Diane Sarkies - objection to buses on robert road App no: SSI5414

SUBMISSION TO NWRL RE ROBERT ROAD CHERRYBROOK

Application number: SSI-5414

Figure 6.12 Cherrybrook Station - Indicative vehicle and pedestrian movements

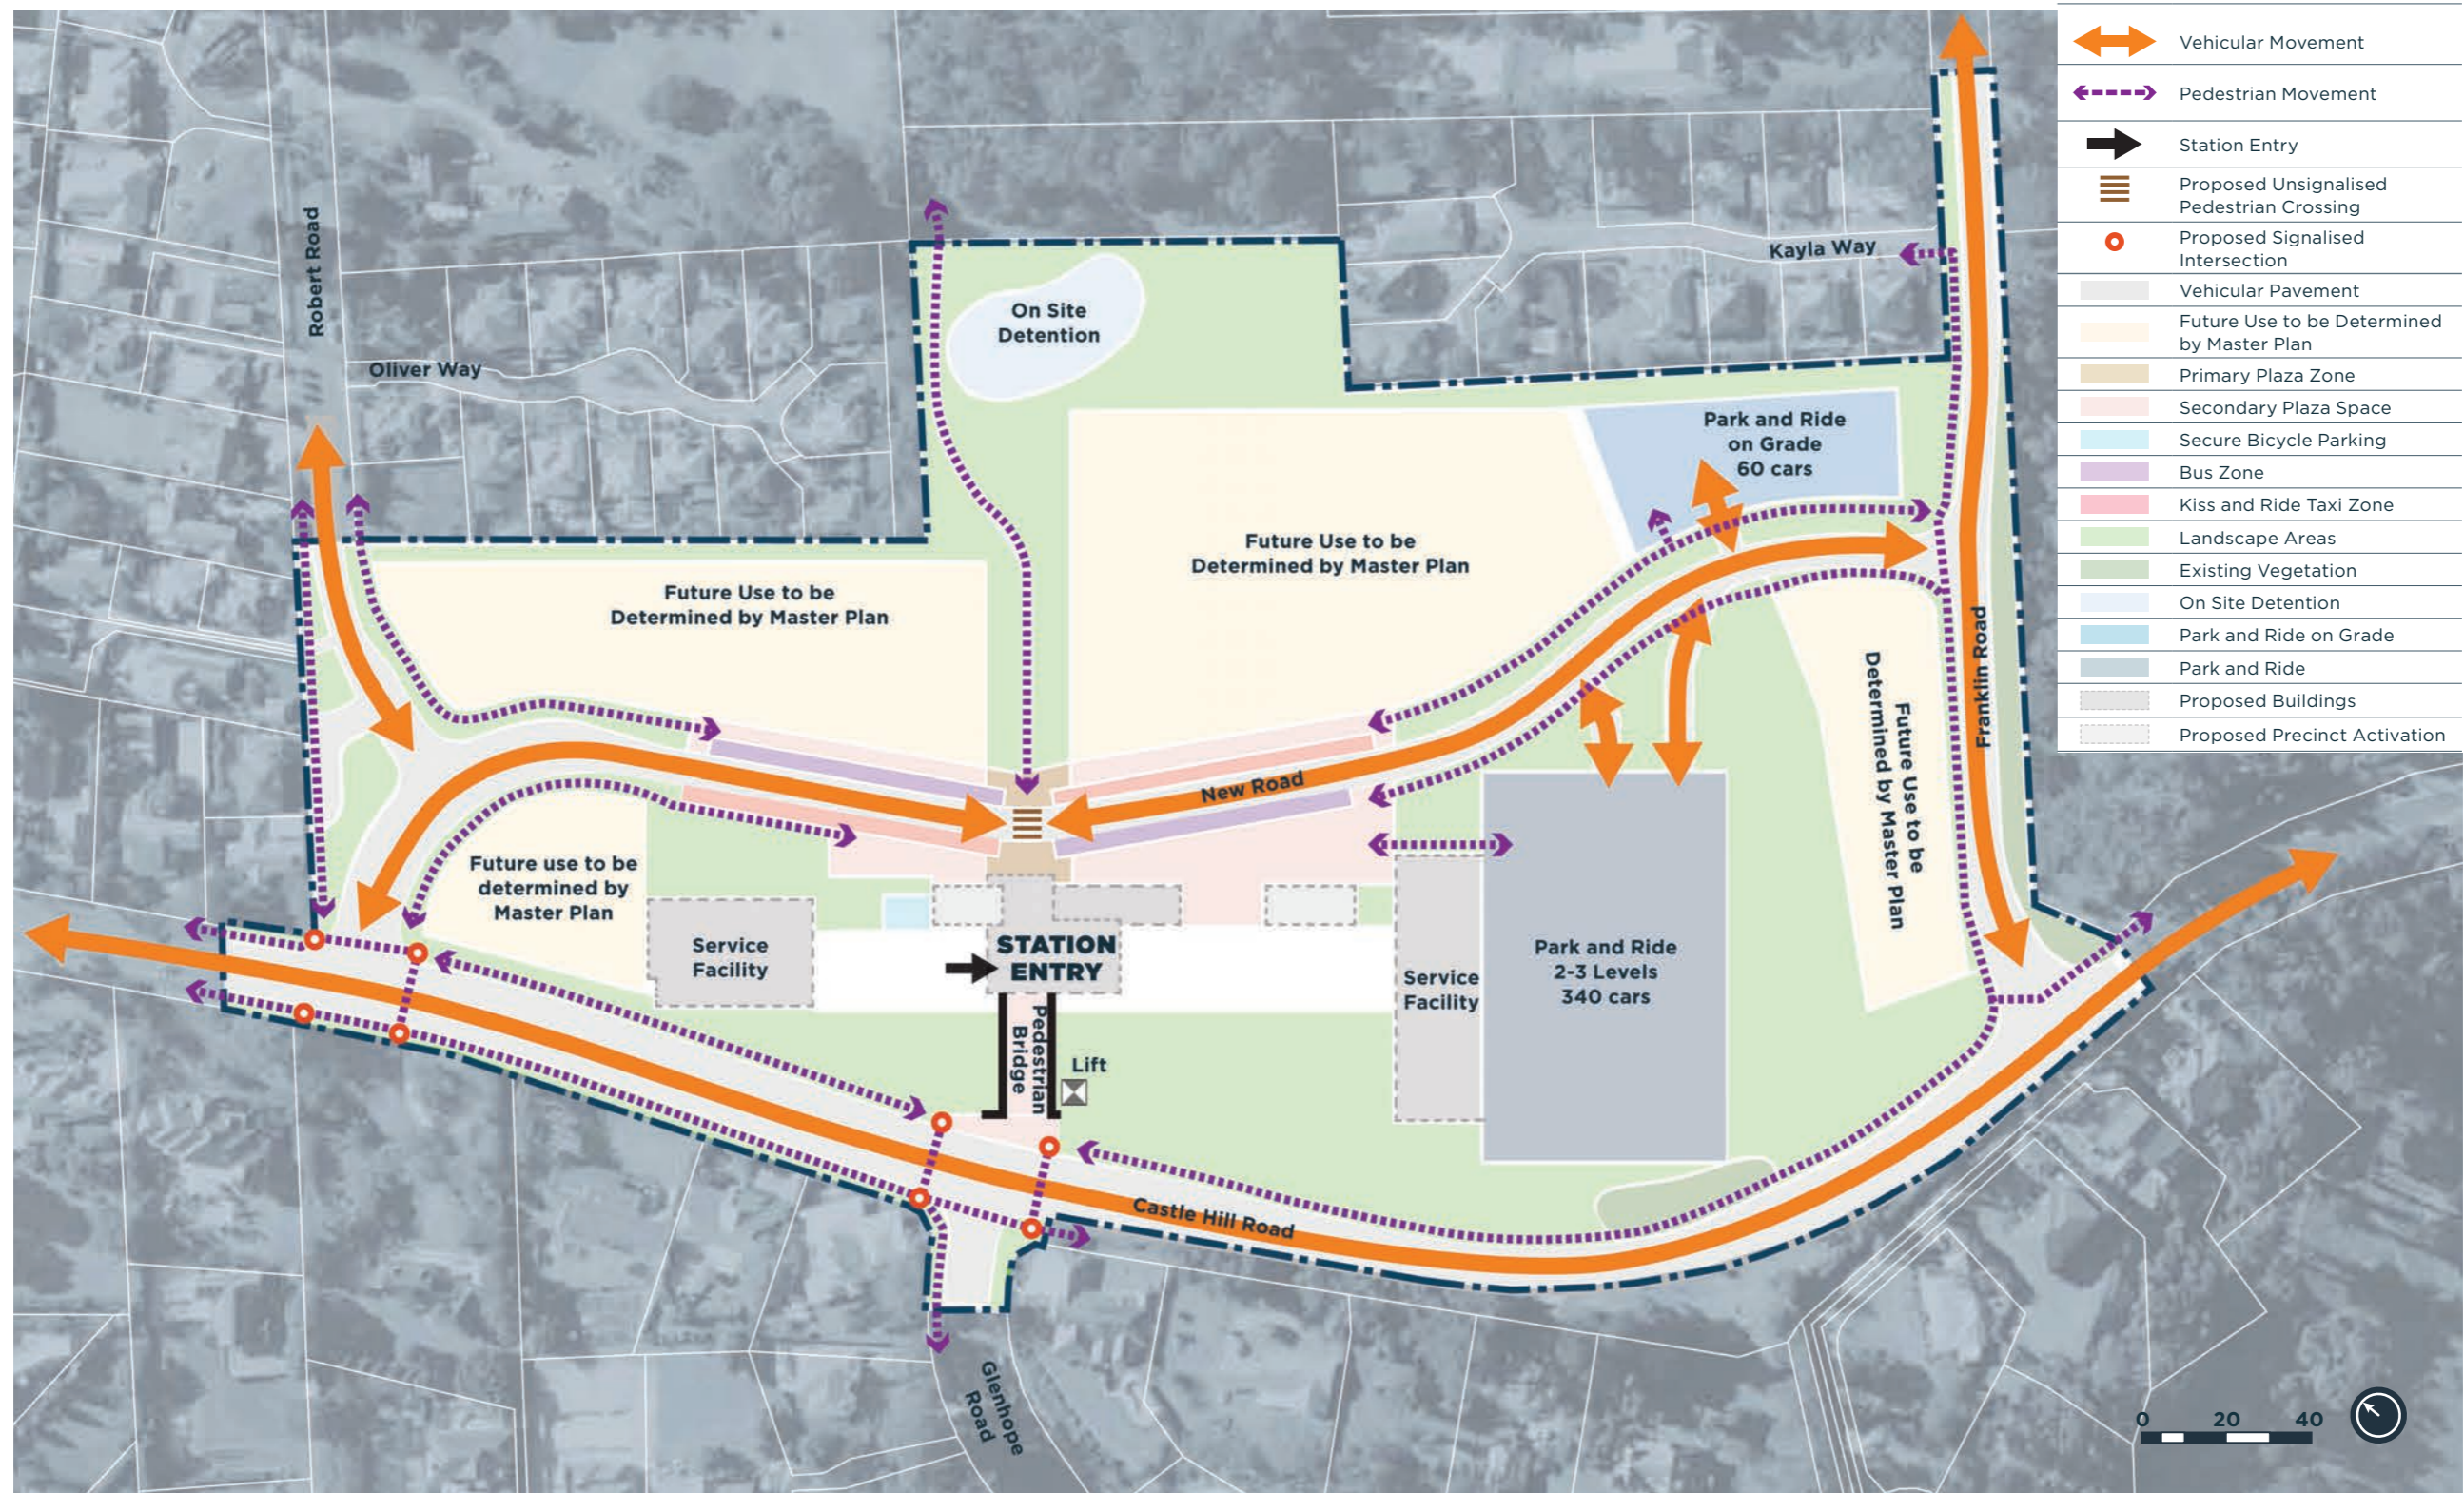
The Arundel Way residents wish to strongly object to Robert Road being used as a feeder road to the yet to be constructed Cherrybrook Railway station.

Specifically we object to public transport, notably buses, using Robert Road to access the new station.

- 1. Robert Road is a narrow road designed for low numbers of vehicles. It is not designed for heavy traffic, particularly large vehicles such as buses.**

- 2. The absurdity of the proposal to use Robert Road is further highlighted by the more sensible option of using County Road and then Castle Hill Road. County Drive is clearly designed for heavy traffic. Robert Road is not. We therefore propose that buses heading south on County Drive continue and turn left into Castle Hill Road and head towards Cherrybrook station, instead of the NWRL proposal of buses heading south on County Drive turn left into John Road and right into Robert Road and then south into Robert Road and onto Cherrybrook Station.**

- 4. Safety issues are paramount. Robert Road is a quiet street, with pedestrians crossing the road at many points, and often, to get access to the park at the corner of Dalkeith Road. No pedestrian crossing exists.**

- 5. Cars existing Arundel Way will not be able to exit safely. The increased traffic of large vehicles will obstruct vision. This also applies to residents of other cul-de-sacs off Robert Road such as Louise Way and Oliver Way. Accidents are bound to happen with the toxic combination of large vehicles and a narrow street.**
